From: Amanda Scholes <Amanda.Scholes@arun.gov.uk> **On Behalf Of** Planning.Responses
Sent: 14 July 2020 11:26
To: Planning Scanning <Planning.Scanning@arun.gov.uk>
Subject: FW: FW: FW: Planning Consultation on: BN/57/20/DOC

Please upload onto Ocella the email trail below which is the consultation response from **ADC Drainage Engineers** to discharge of condition application **BN/57/20/DOC** regarding The Lillies, Yapton Road, Barnham.

I have received the following email and attachment from John Freeman regarding discharge of condition application **BN/57/20/DOC** regarding the Lillies, Yapton Road, Barnham.

TITLE YAPTON ROAD  
BARNHAM  
DETAILS SUDS CROSS SECTION

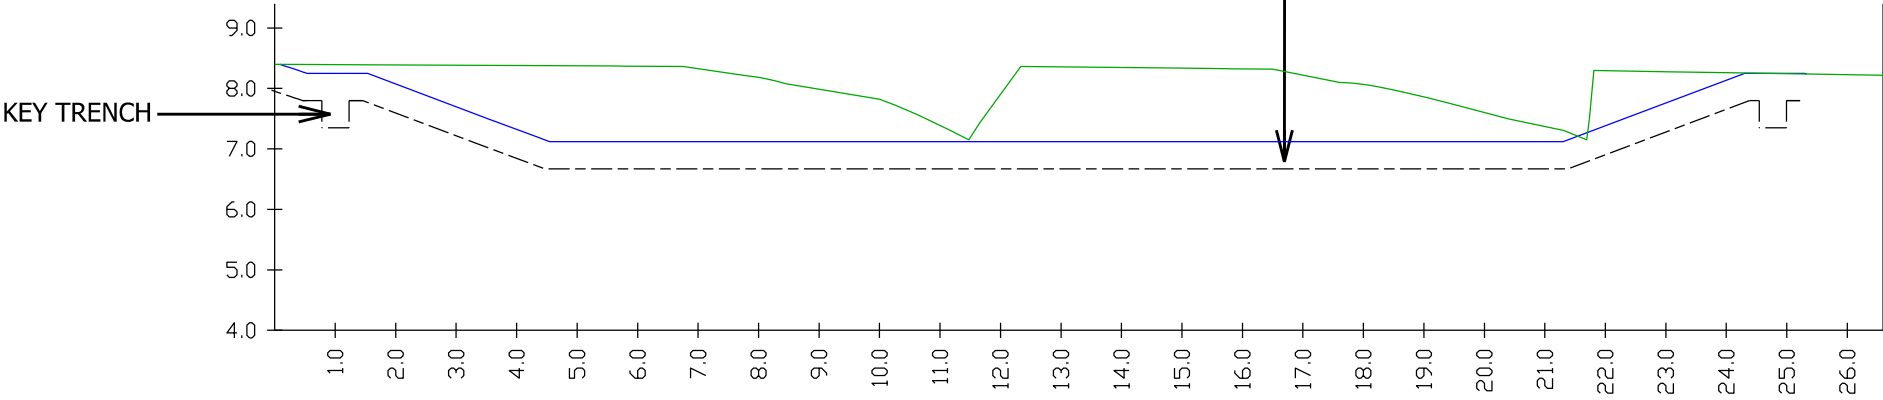
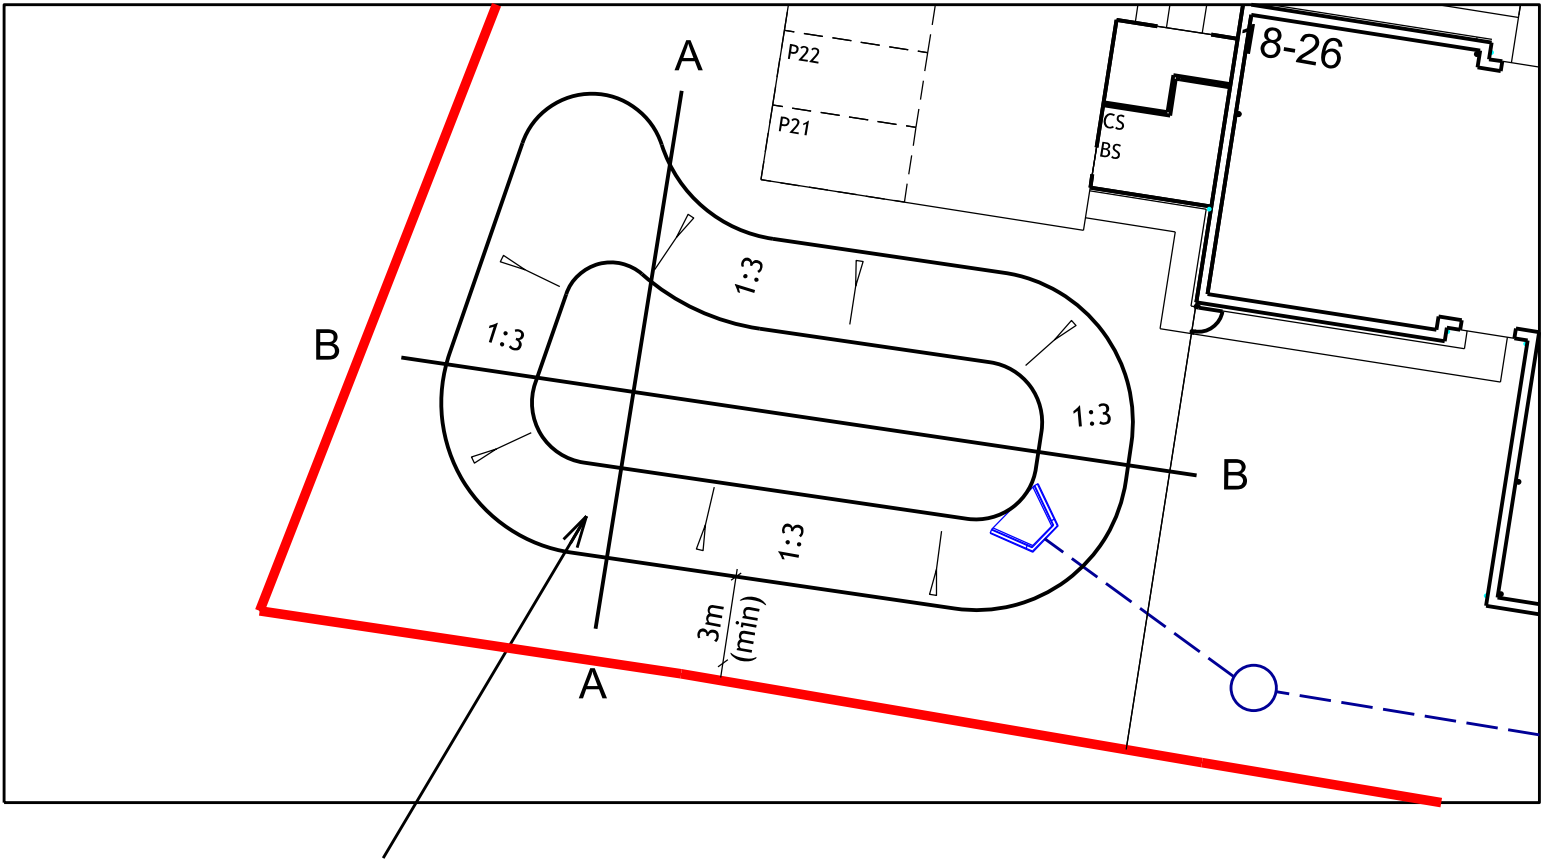
20. -
21. -
22. -
23. Ok
24. Winter groundwater monitoring was undertaken on the development site immediately next door to the west. They encountered standing groundwater levels between 600mm and 1000mm deep which is comparable to our knowledge of Barnham. In fact levels can be much higher. Therefore, the pond will need to receive an impermeable liner to prevent groundwater flowing into the system. Provide construction detail/floatation calcs. We note this is different to being asked to assume ground water is at ground level. We also note that the SI done on our site indicates that the ground water in the (typically wet) months the two SI's were undertaken was not this high. Notwithstanding we have undertaken the calcs and they are as follows. If you do assume a dry pond and groundwater at finished ground level, you'll need sufficient soil above the liner to equal 188m³ of water (pond volume), ie 188 tonnes. With soil at 2 tonnes/m² this means 94m³ of soil are required. For a 246m² pond area, the soil thickness over the liner will need to be 380mm thick throughout. Therefore an impermeable liner will be installed, with 380mm of as dug material placed over it.

SCALE	1:200 @ A1	DATE	JULY 2019
DRAWN	WFN	CHK	SD
DRAWING NO.	17748-BARN-5-601	REV	H
TITLE	YAPTON ROAD BARNHAM		
DETAILS	ENGINEERING LAYOUT SHEET 2

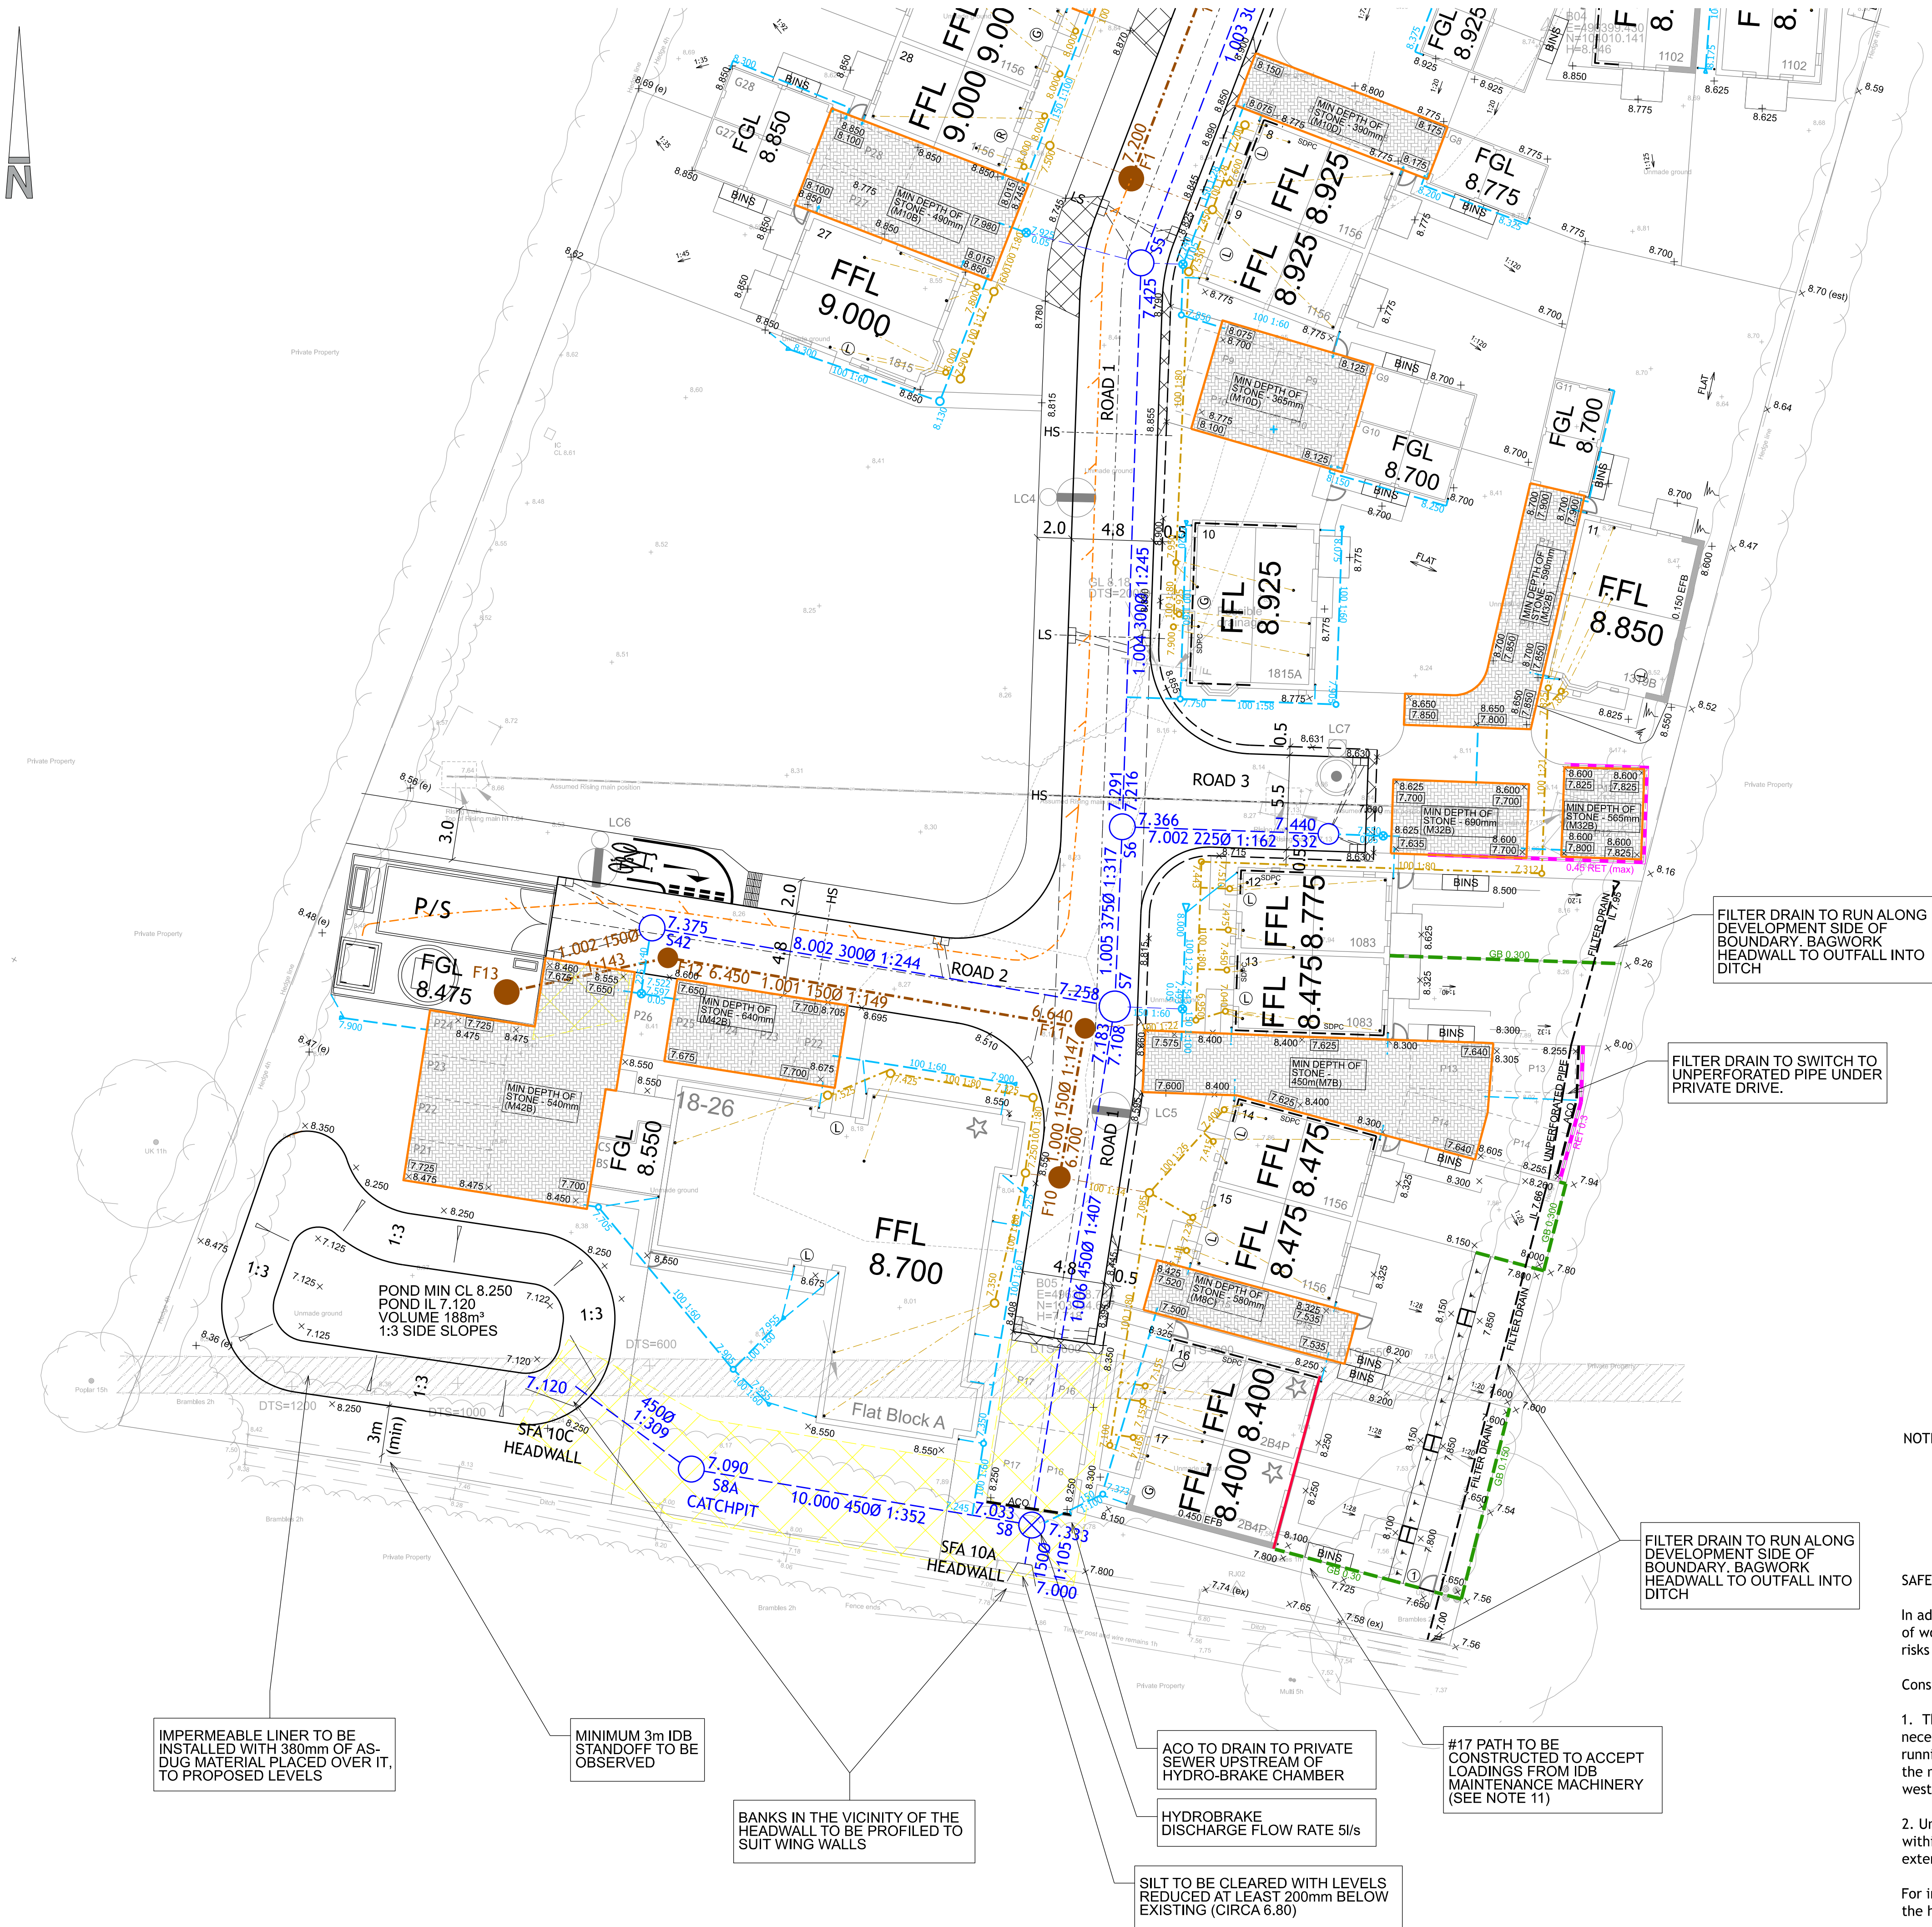
16. Indicate the depth of pipe cover to suit each bedding type detail, on the drawing. *Amended*
17. -
18. -
19. Ok (Drawing 601 amended), drawing 600 needs to be too. *Amended*

37. Await Southern Waters response.
38. Filter drain noted, however it needs to extend up to and including the rear of plot 12. Specify a 100mm pipe as opposed to 50mm. Rodding eye or manhole access required at head of run. Simple concrete bag headwall to be in accordance with the enclosed detail. *Adjusted*

RAINWATER DOWNPIPE DIRECT CONNECTION TO PERMEABLE PAVING

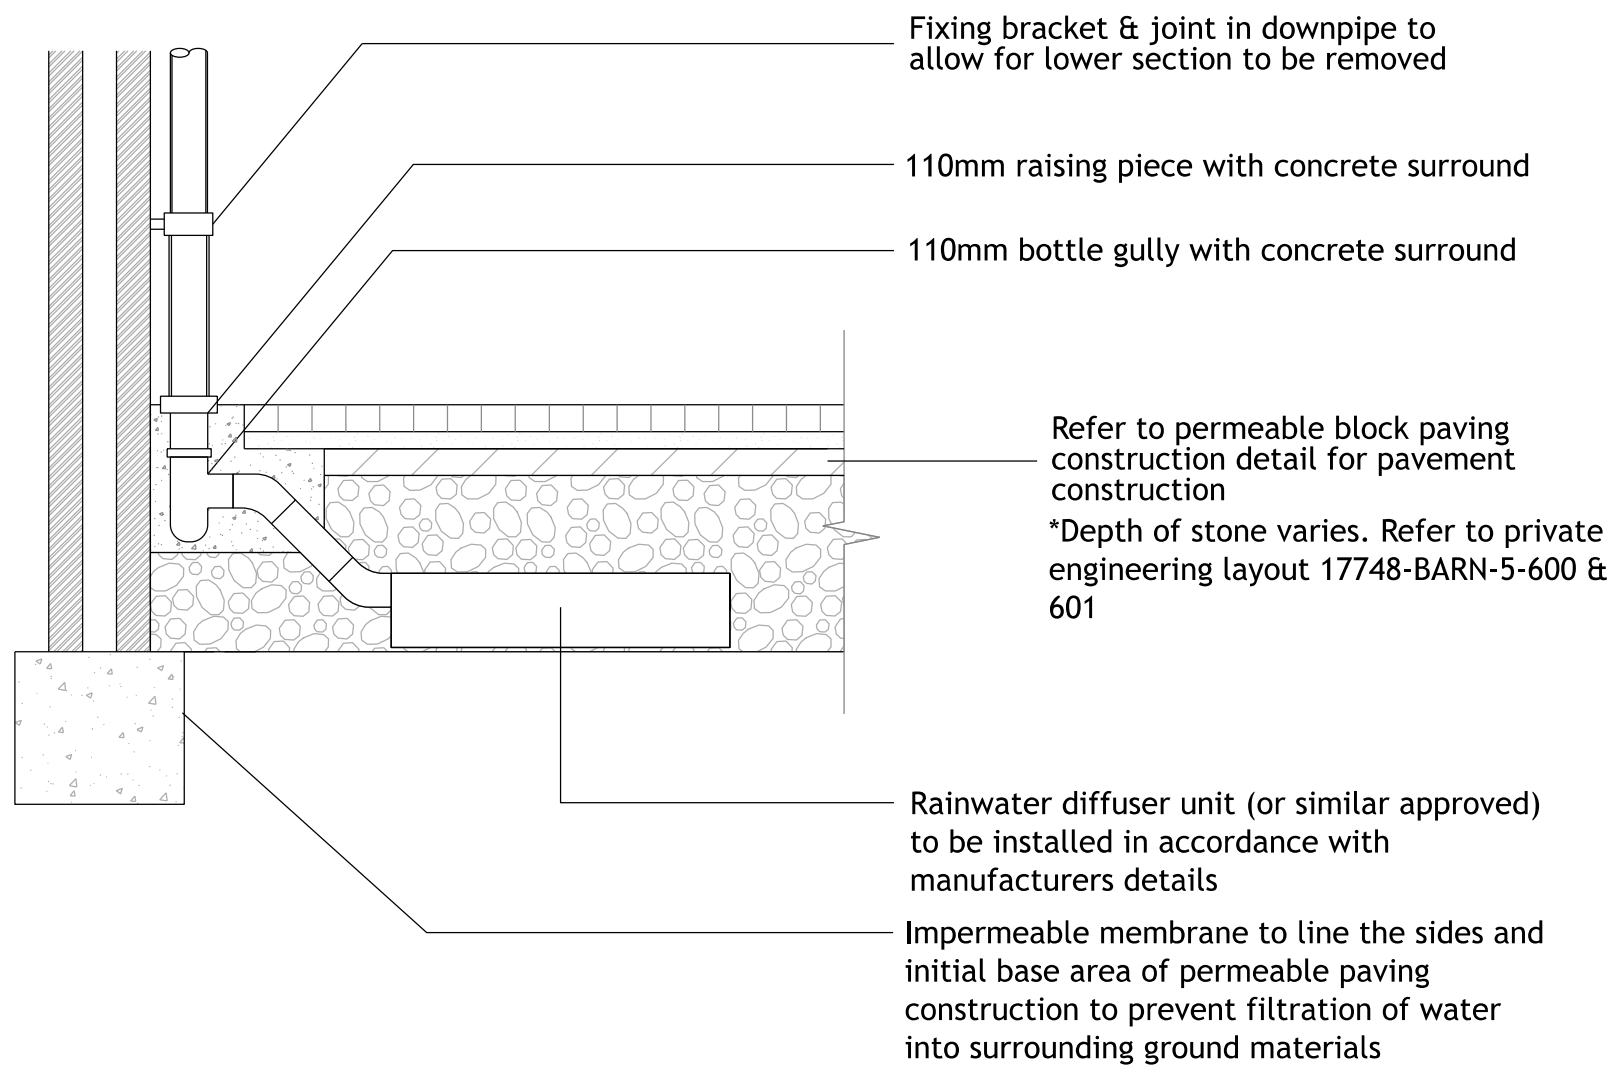
3. Ok
4. -
5. -
6. Bottle gully detail noted. Rather than have a removable section of downpipe, it would be preferred for the downpipe to discharge onto a grated cover to collect any larger items of debris before they can enter the system. It is critical that the diffuser units are protected as much as possible. Once any debris/silt is in the diffuser, then the only way to get it out is to dig it up. Hence, a grated cover gives easy visual access into the gully, so maintenance/issues can be recognised more readily. Please adjust and make specific reference to their importance/arrangement in the maintenance manual. We have added a note to all relevant drawings that balloon leaf guards are to be added to all gutters.
